ENG-SP20008-R3-PrelimPlan-redlines.pdf Markup Summary

522800030, 523300014
SKP 18-003 (Approved 2018)
RR-6 (NOT Correct)
RS-6000
Fall/Winter 2021
Single Family Residential
27.26 ac - 147 Lots (95%)

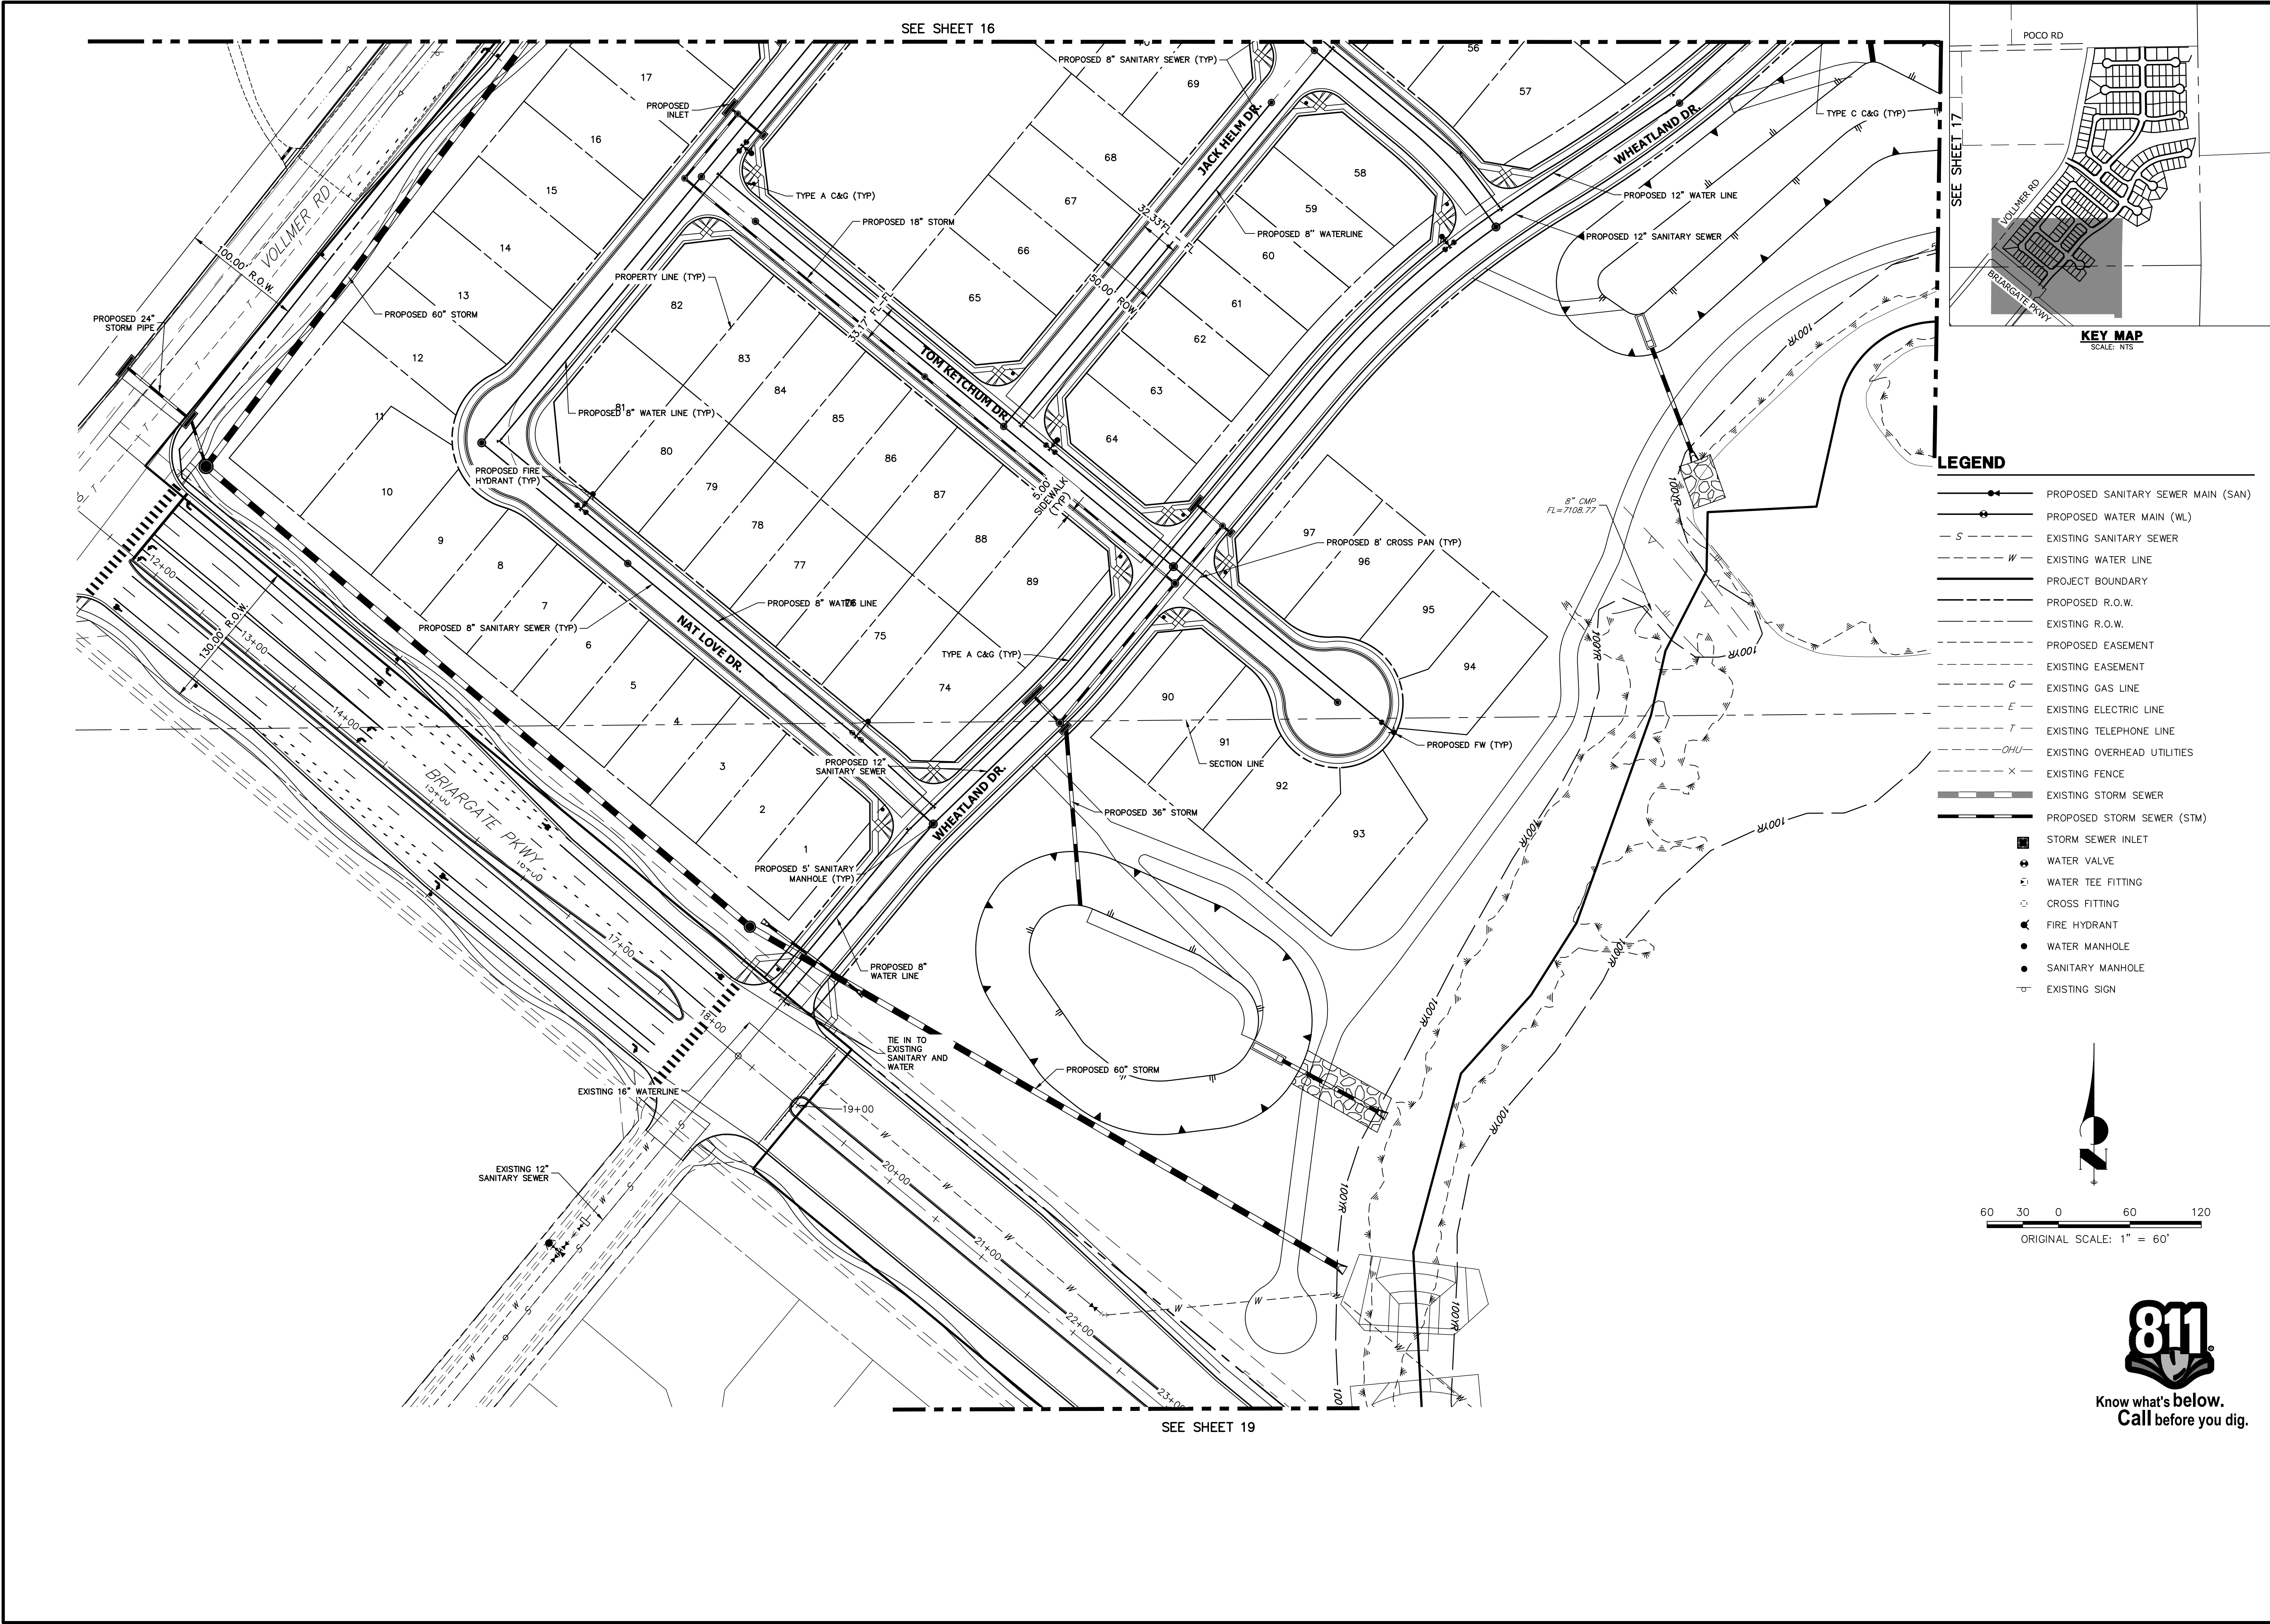
Show rundown conveyance

Pipe has to flow into the FSD

24 OF 25

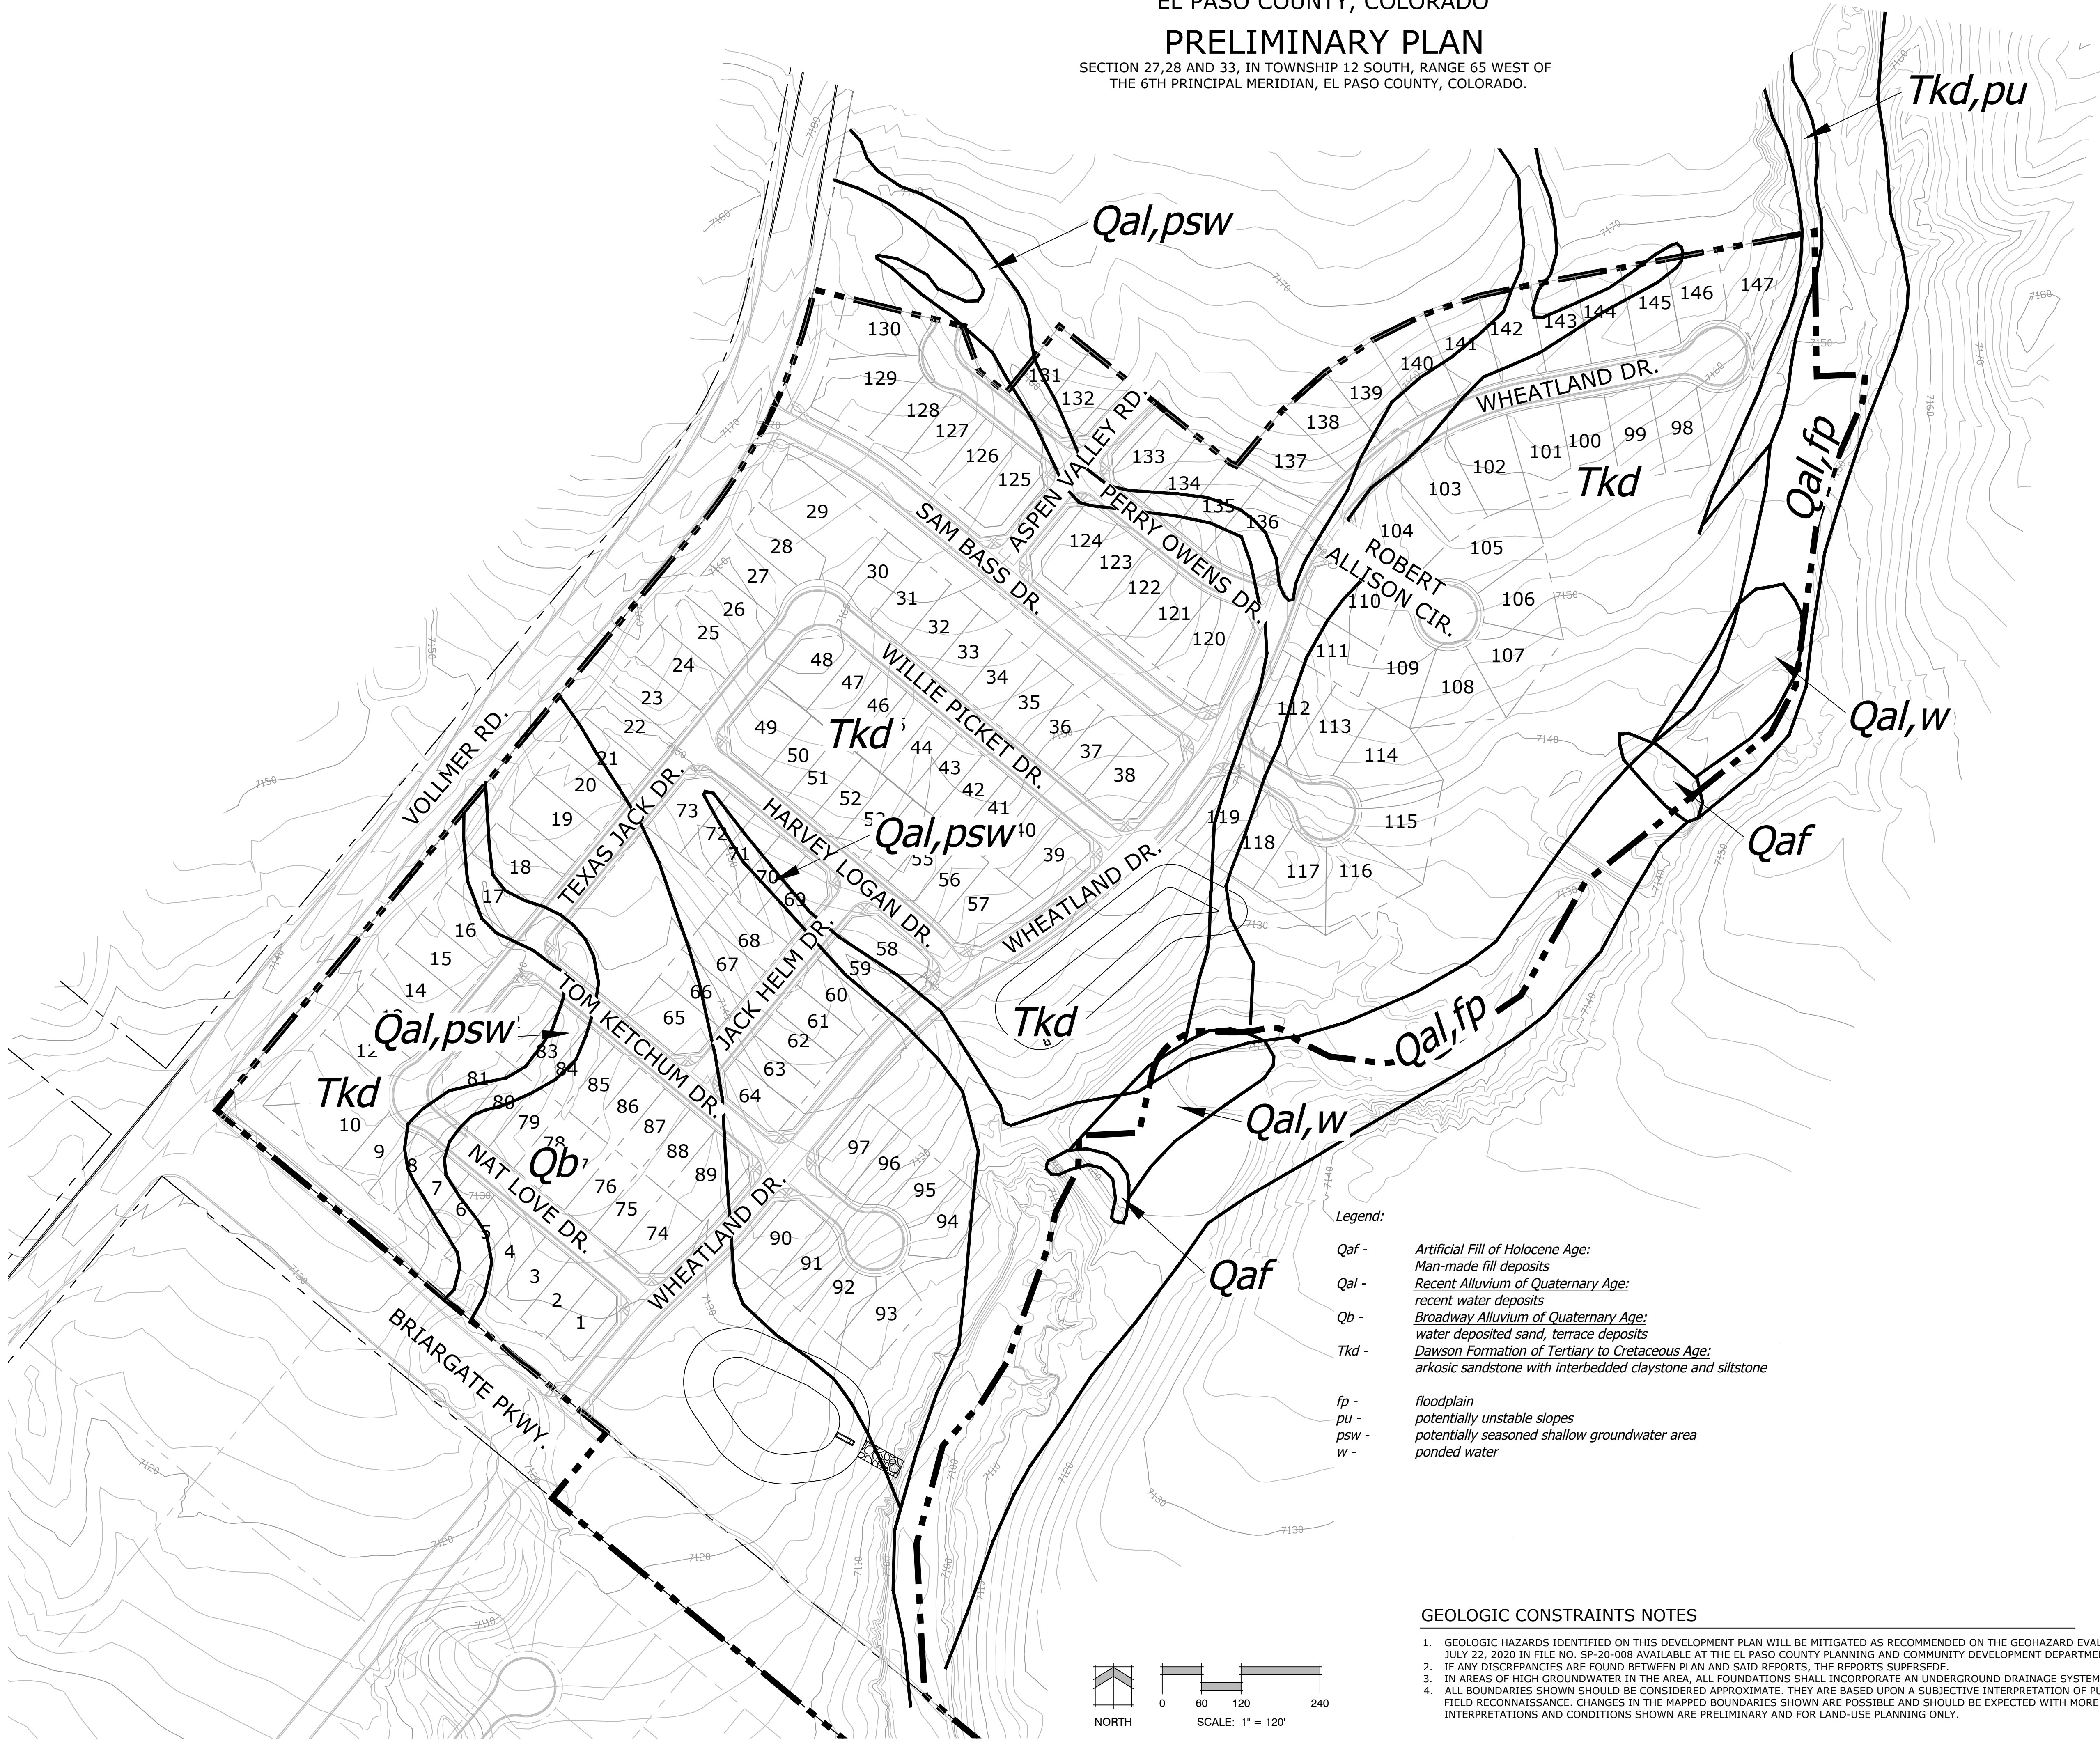
Potentially unstable slopes need to be addressed.
How far west does stabilization need to go?
